**WELWYN HATFIELD COUNCIL – DEVELOPMENT CONTROL**  
**DELEGATED REPORT**

| <b>APPLICATION No:</b> | <b>S6/2007/1351/FP</b> |

The application seeks full planning permission to erect a 1 ½ storey detached garage to the north east site boundary of the property. The detached garage would be situated to the far end of the rear garden and would be incidental to the main dwelling.

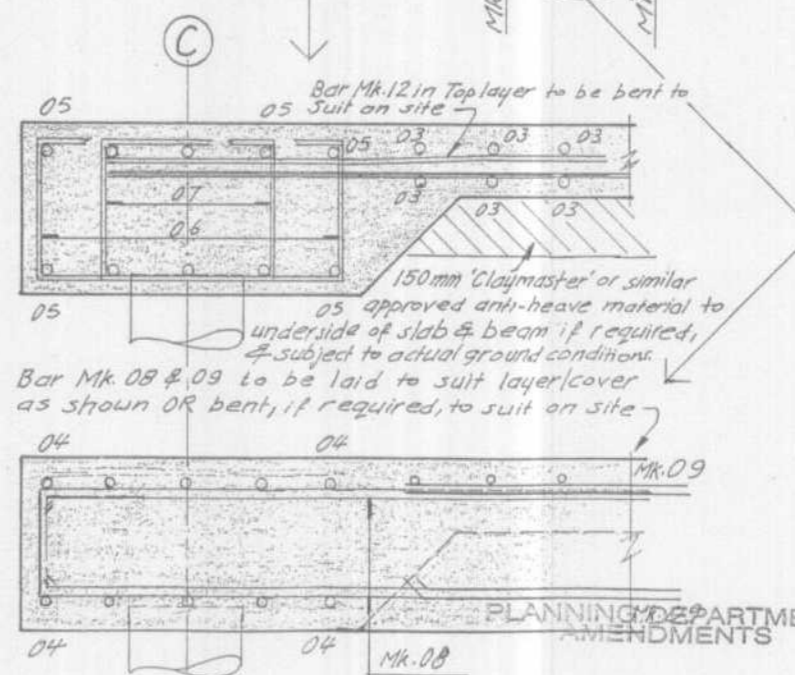
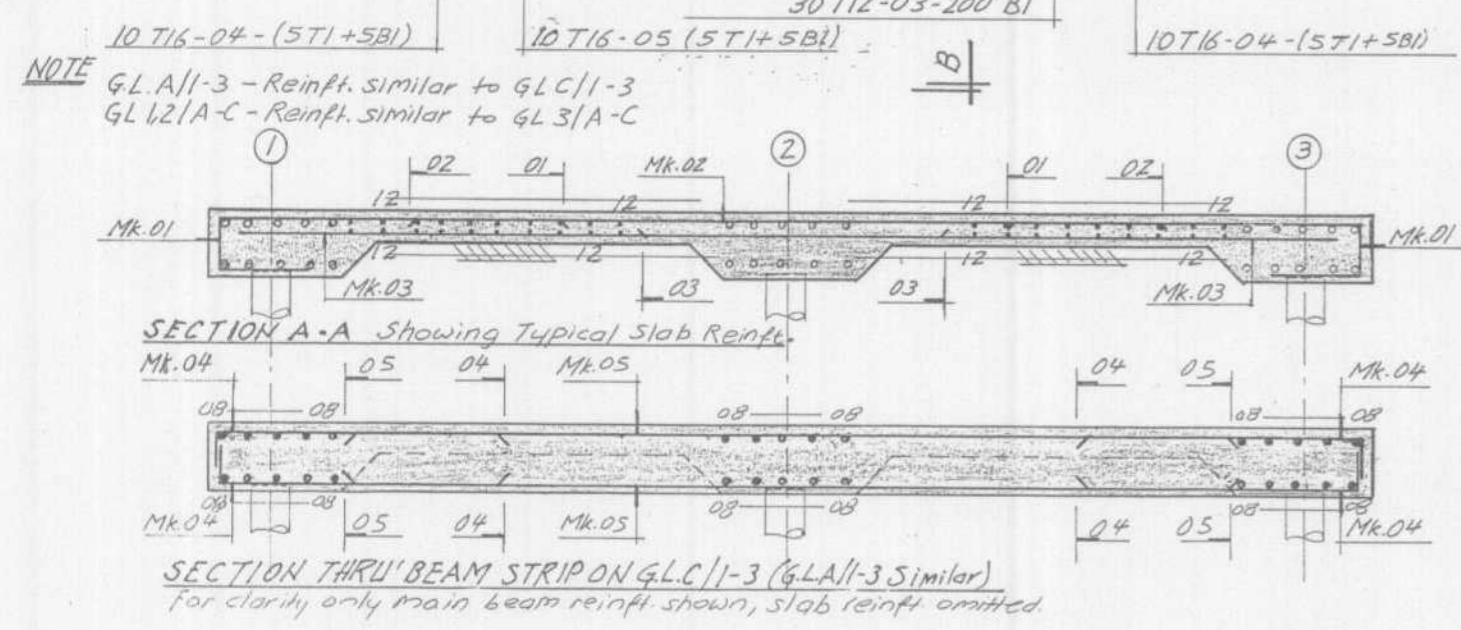
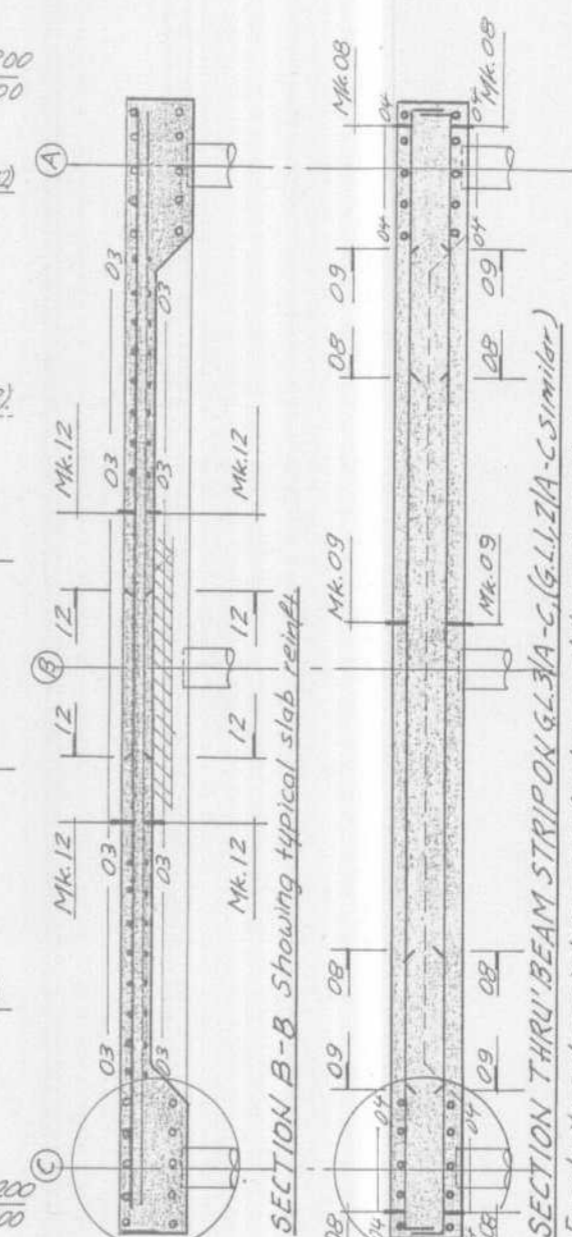
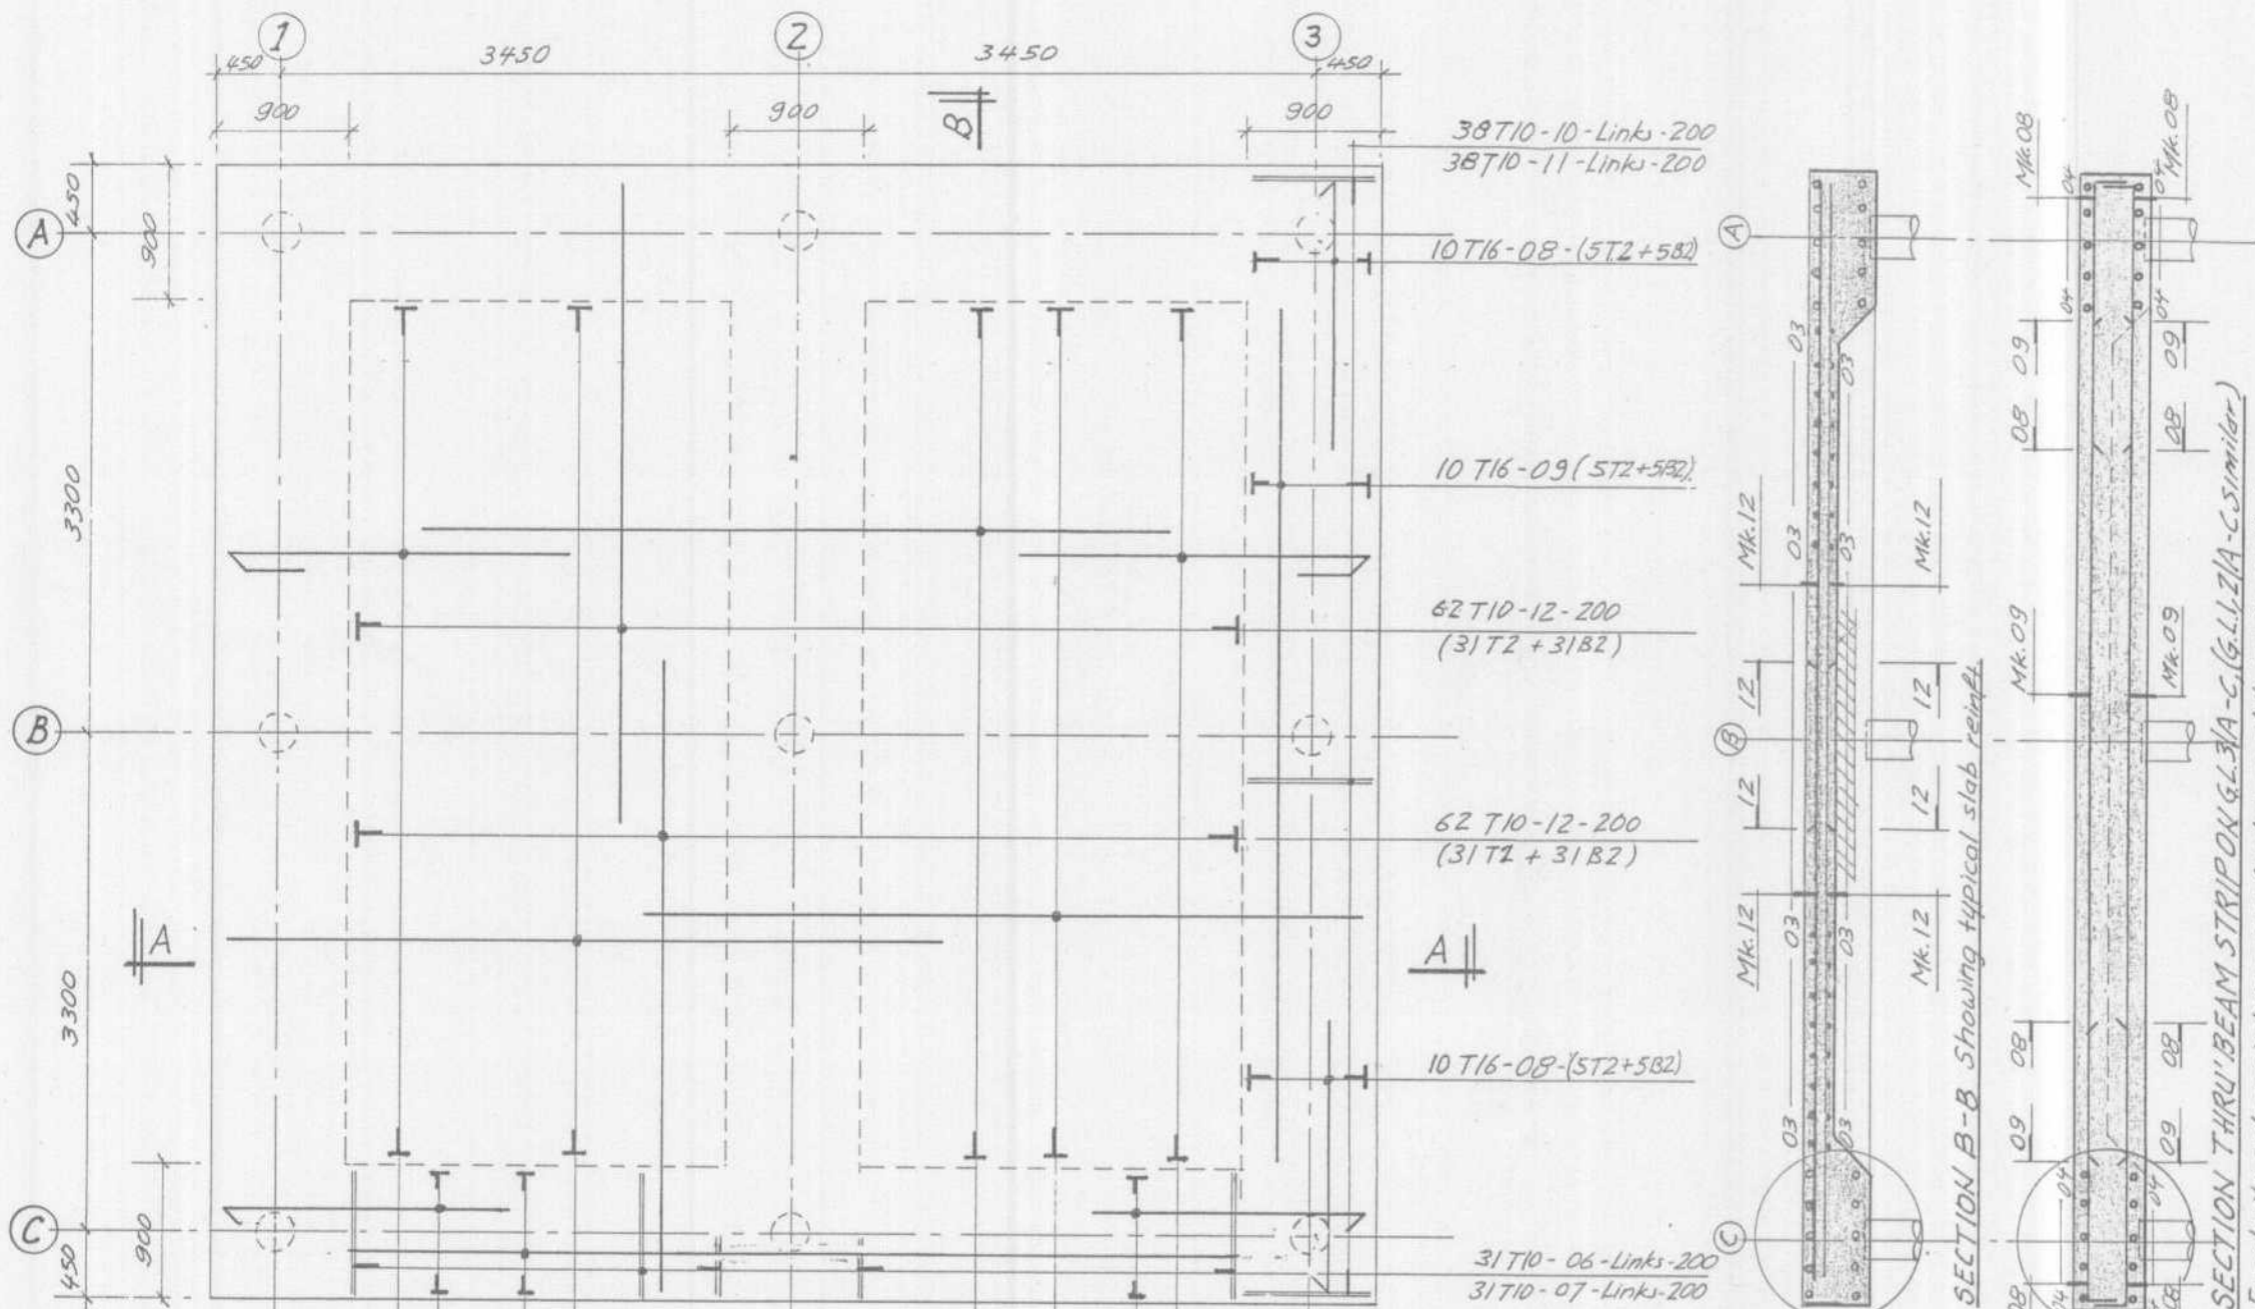
Landscaping – objected to the first scheme which was considered could harm the health of the protected trees. Amended plans – verbally confirmed acceptance to proposed foundations and reduction in height of garage should protect crown of oak tree.

The plan showing details of the pile and beam foundations (MD/10-07/SE-01) is considered would ensure the ongoing health of the oak tree and would thus comply with policy.

1. C.2.1 – Time Limit
2. C.5.1 – Samples of materials
3. The foundations shall be finished as pile and beam as shown on drawing MD/10-07/SE-01.  
REASON: To ensure that the building works do not prejudice the health and retention of the protected tree, in accordance with policy R17 of the Welwyn Hatfield District Plan 2005.
4. The building hereby permitted shall only be used for a purpose incidental to the enjoyment of the dwellinghouse within the application site and for no other purpose.  
REASON: to ensure the Local Planning Authority retains control over any future development and to protect the amenities of adjoining occupiers in accordance with policy D1 of the Welwyn Hatfield District Plan 2005.
